**Consultation Response from KC,
Highways Development Management**

2024/90769 adj, 27, Riley Park, Kirkburton, Huddersfield, HD8 0SA

Erection of one detached dwelling and associated works

Date Responded: 22-7-2024.

Drawn	Checked	Date	Scale	Revision
DB	AH	18/08/2023	1 : 100 @ A1	A
Client	Rayner Developments			
Project	Belfry			
Title	Proposed Site			
Dwg No.	3107 -001

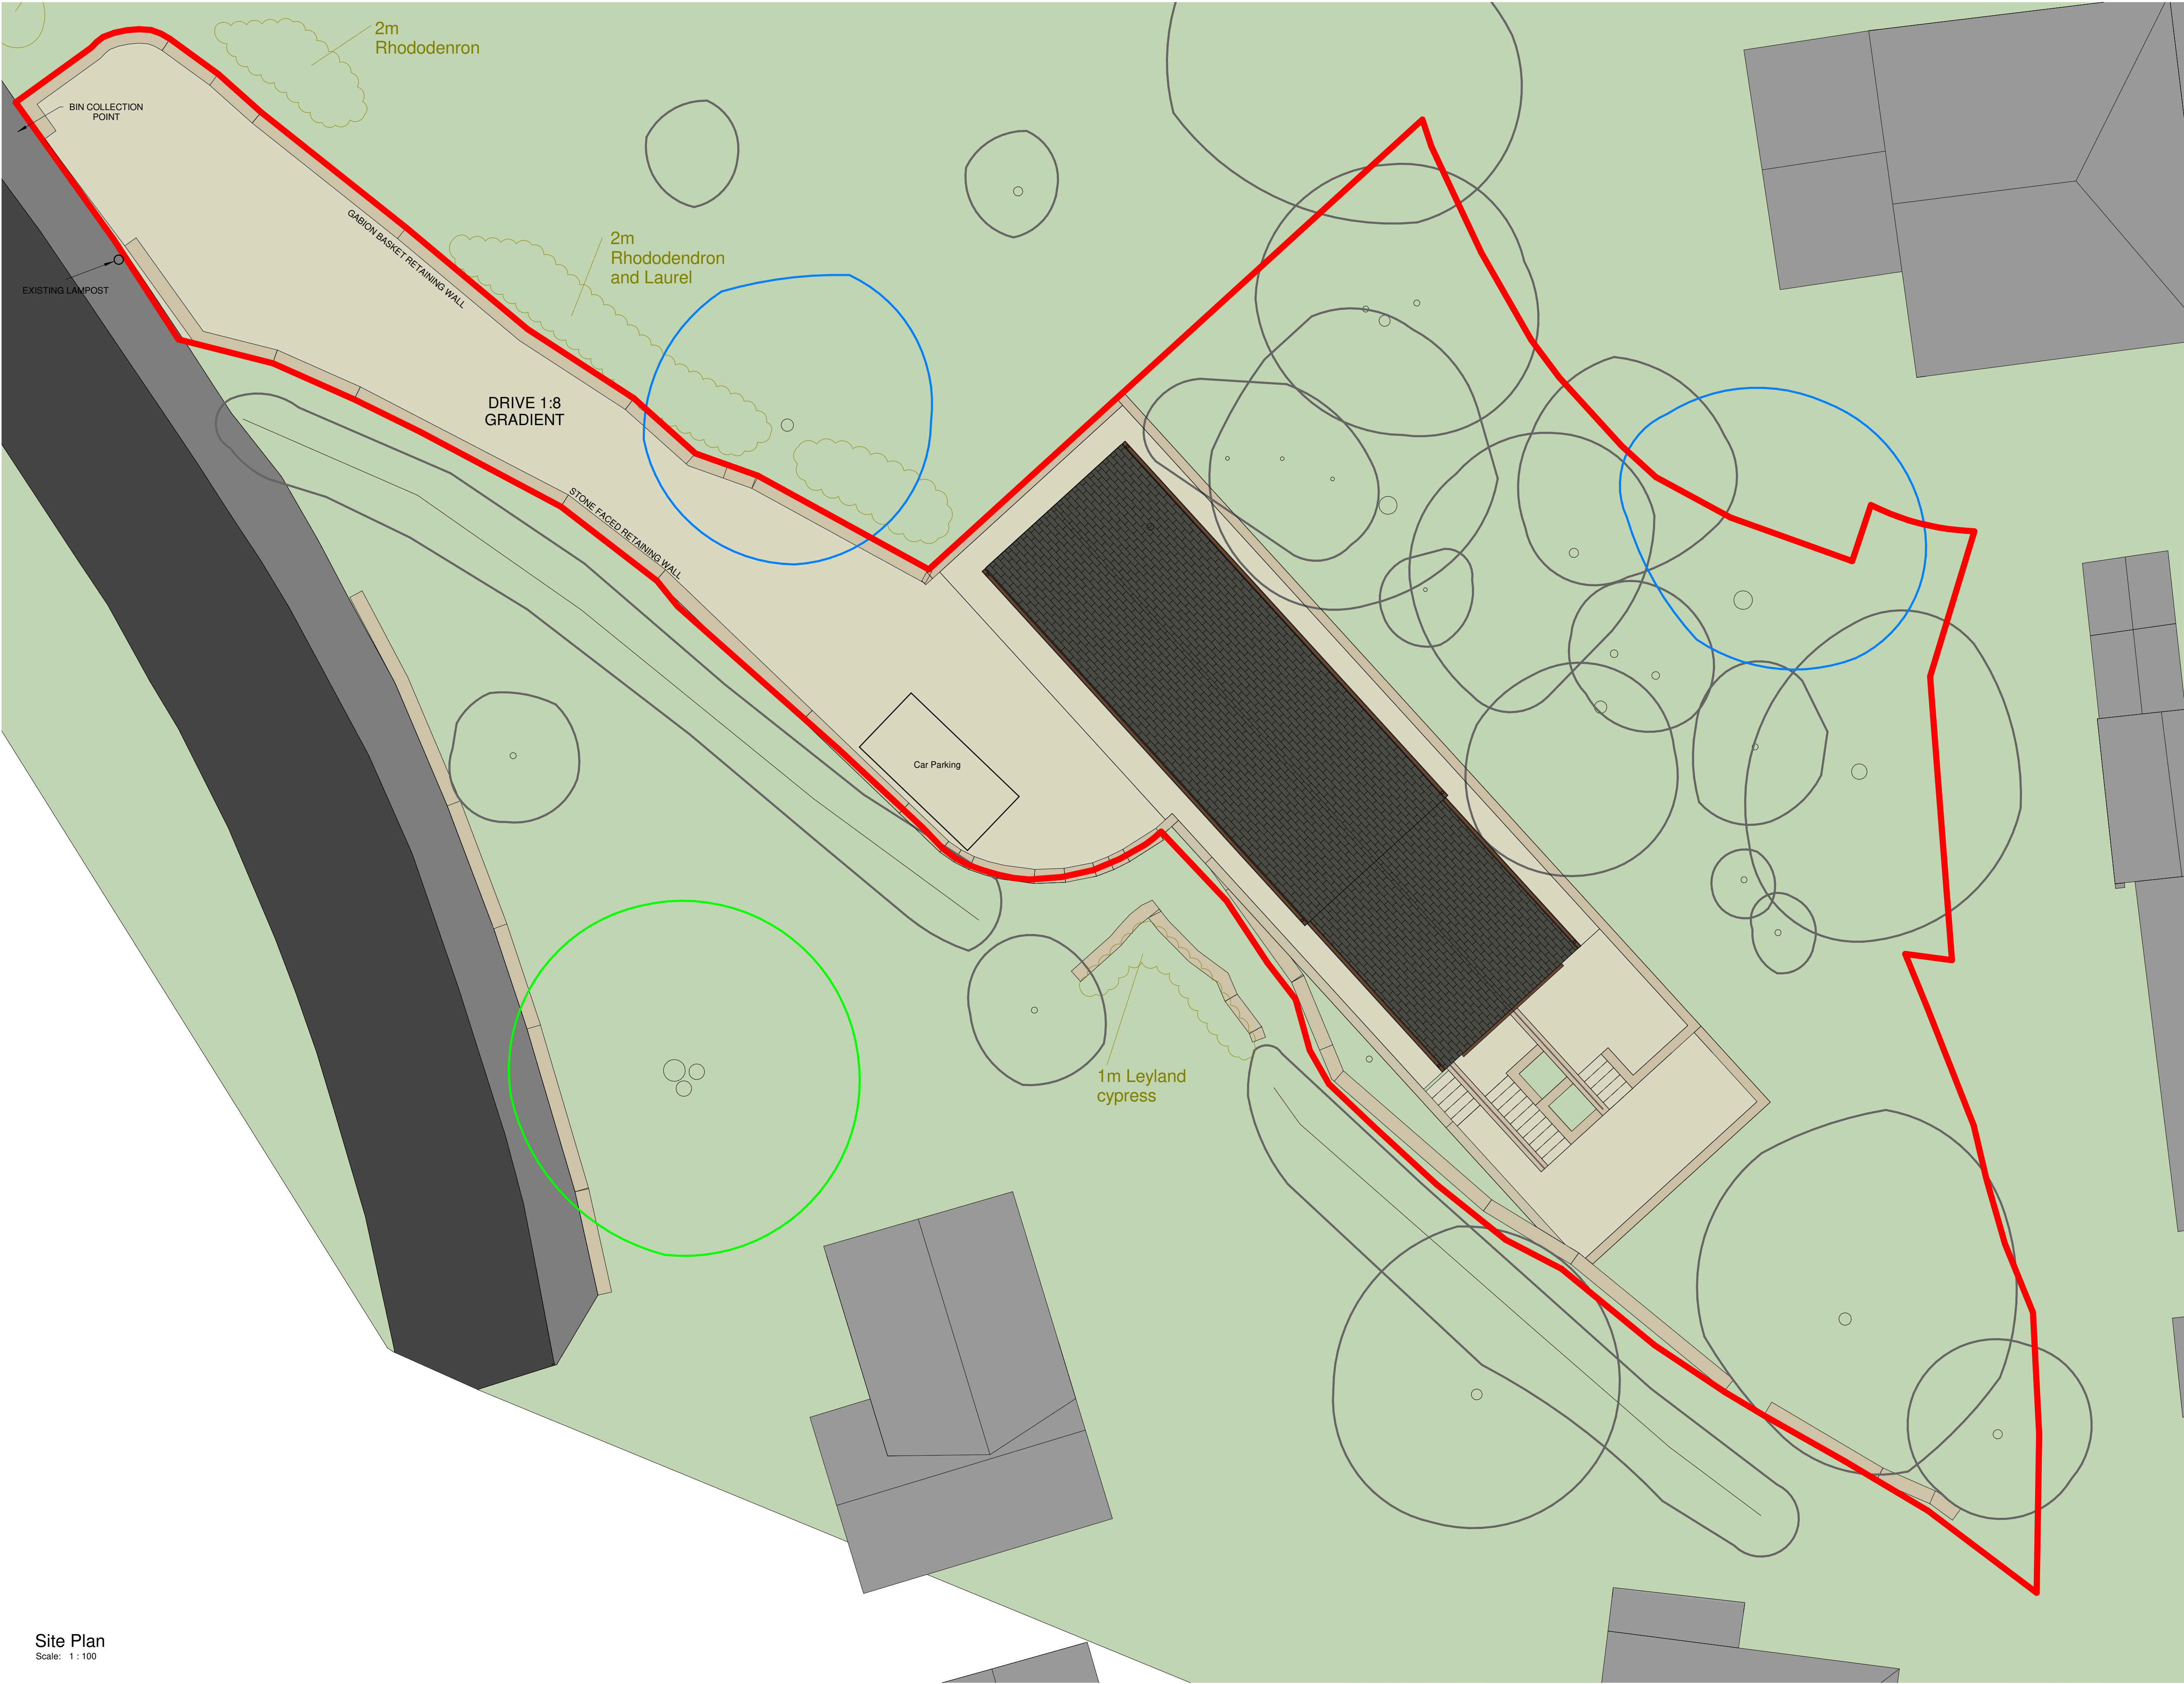
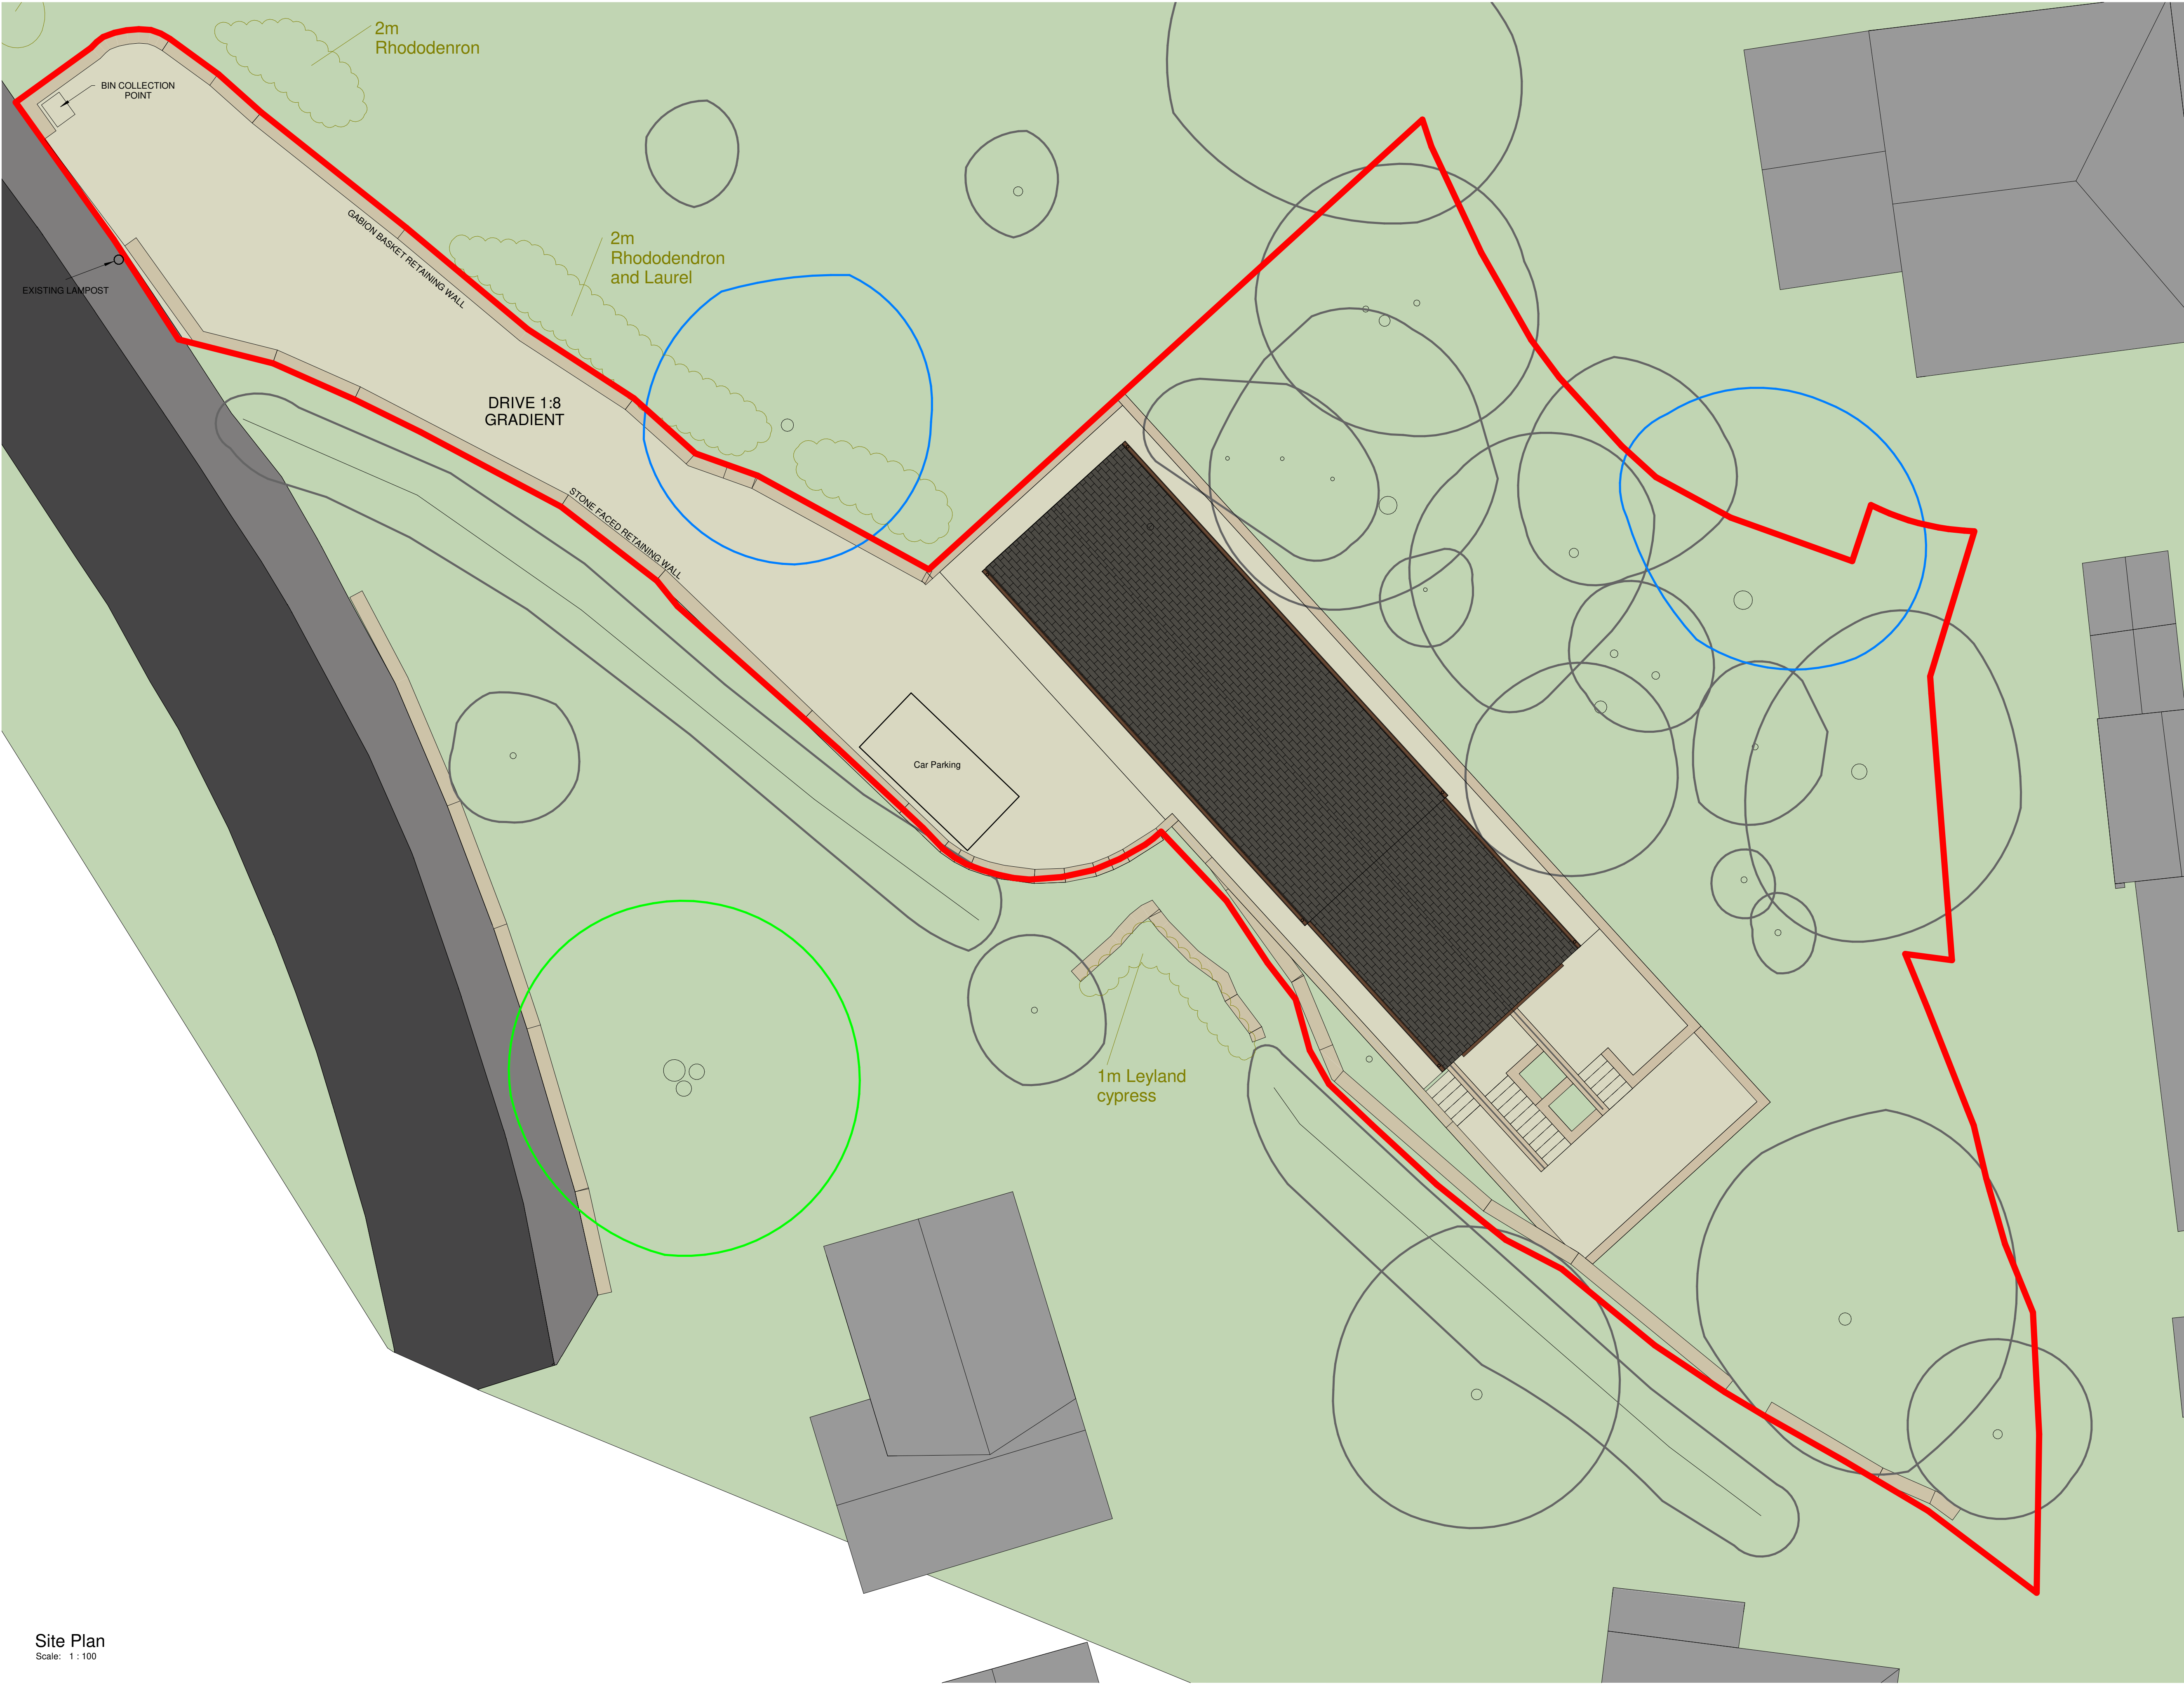
The applicants have provided plan number 3107-001 showing the proposed gradient specified at 1 in 8 and the location of a collection point.

The bin collection point is shown on the Riley Park footway which is unacceptable.

The bin collection point should be shown to be provided to enable bins to be presented on collection day without either obstructing the highway or proposed driveway.
